From: Paul Cann
Sent: 22 January 2018 15:42
To: Planning.Responses
Subject: RE: Planning Consultation on LU/7/18/DOC

APPLICATION NO: LU/7/18/DOC

Site Address: Land adjacent to Shell Garage Worthing Road Littlehampton

Description of Works: Approval of details reserved by condition imposed under LU/20/17/PI relating to condition 4-surface water drainage.

|           | <b>Soakaway Test Results<br/>(after BRE Digest 365)</b> | <b>Geo-Environmental Services Limited</b><br>Unit 7 Danworth Farm, Cuckfield Road,<br>Hurstpierpoint, West Sussex BN6 9GL<br>+44(0)1273 832972 www.gesi.net |

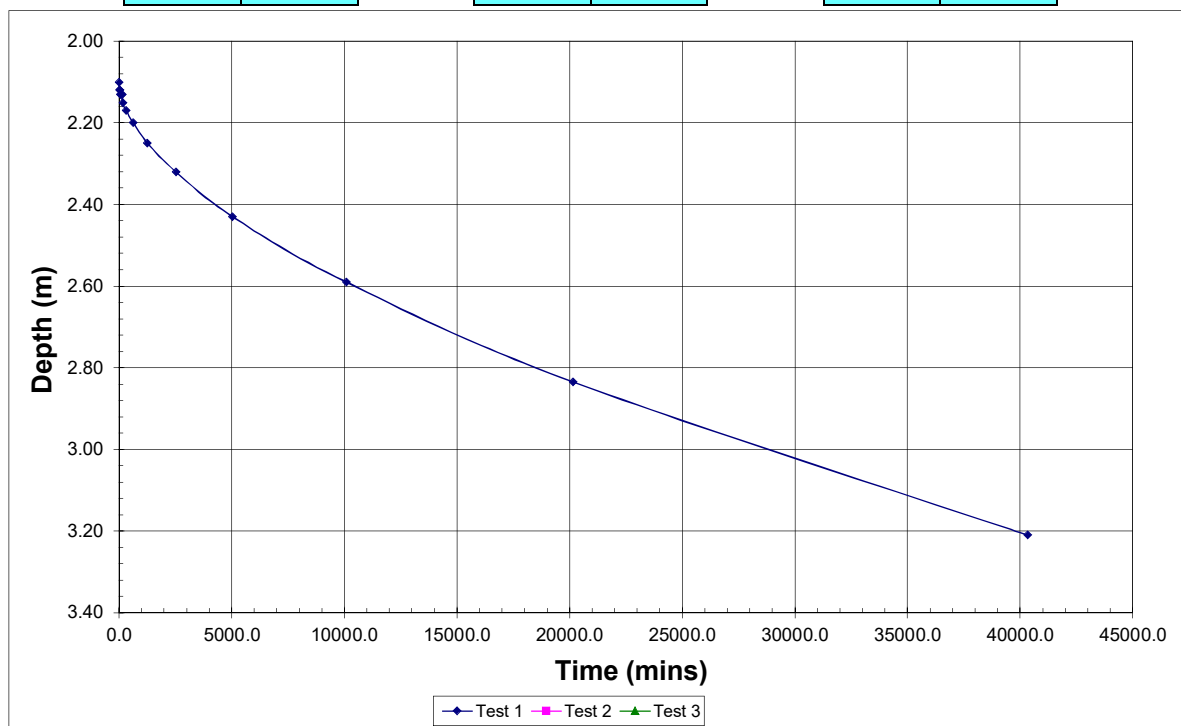
It is noted that the percolation testing/groundwater observations have been carried out in May/June ie. outside the required winter period.

The percolation rate is detailed as 'negligible' however, a rate (m/s) has not specified.

Before the proposals can be considered further, please provide more information on the percolation rate achieved. This will determine if further testing, etc is required. We need to be satisfied that infiltration has been fully investigated before other options are considered.
